Application for Planning Permission

Development: Portable toilets with decking and a timber screen fence to match the existing. In CIL Zone 4 (Zero Rated) as other development.
Location: Salt Beach Kiosk Sea Road East Preston BN16 1PD

Rev	Notes	Date
 M: 07599199759 E: info@nat-design.co.uk www.nat-design.co.uk		
Project: Salt Beach Kiosk Sea Road, East Preston, BN16 1PD		
Drawing: Proposed Fence Elevations		
Drawn by NSE	Scale as shown	
Date August 2026	Revision	
Drawing 2067 - DPA - 05

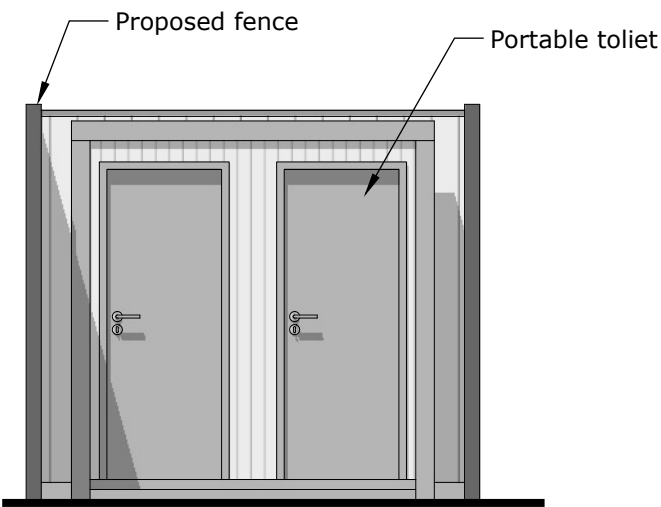
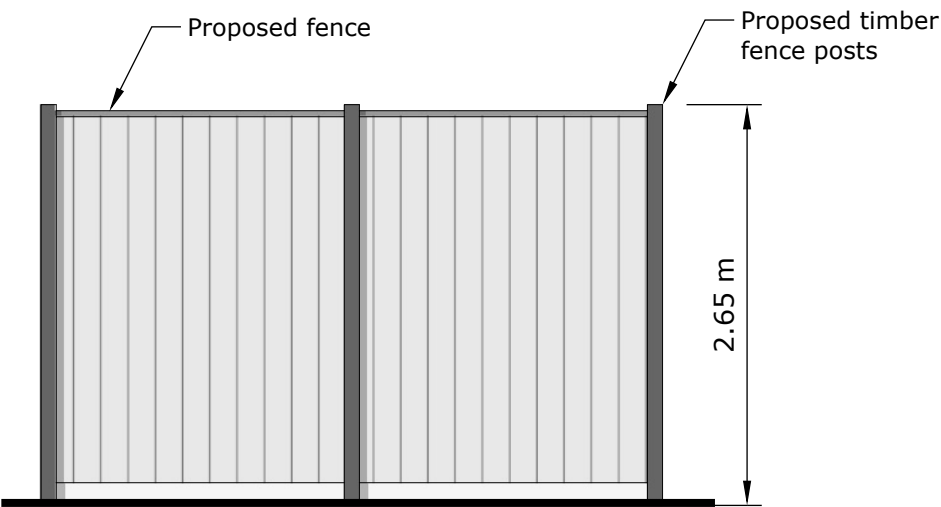
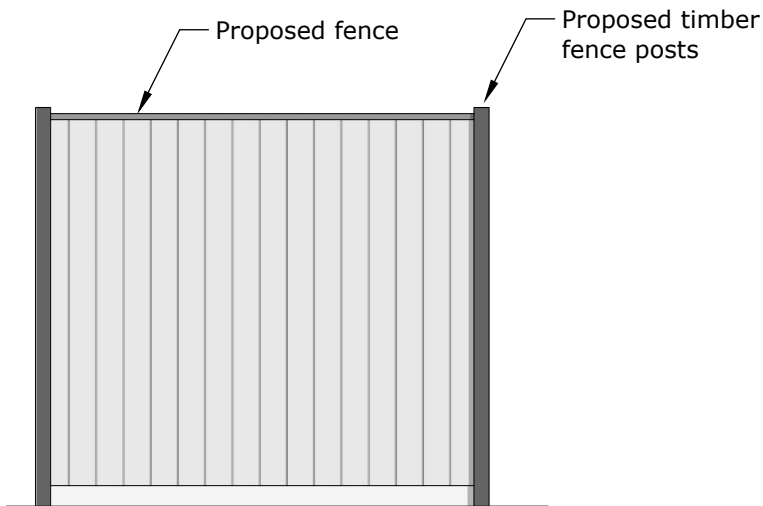
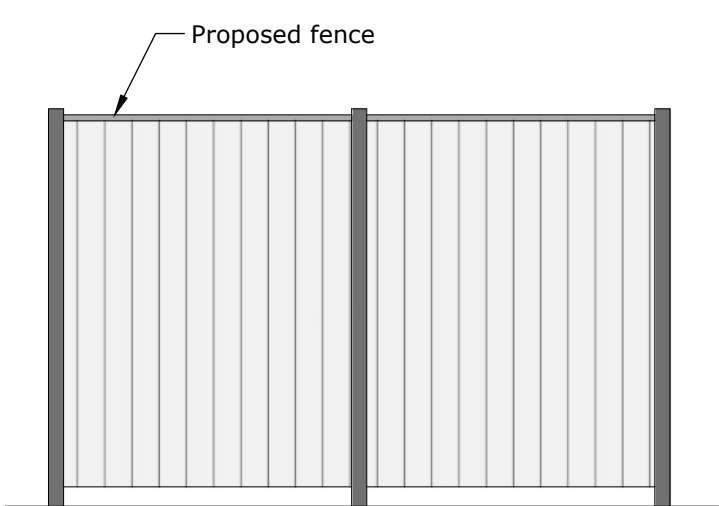
Elevations

Please submit elevations of the fencing to show material, style and colour.

Fence height

Please confirm the fence height for the description of the proposal.
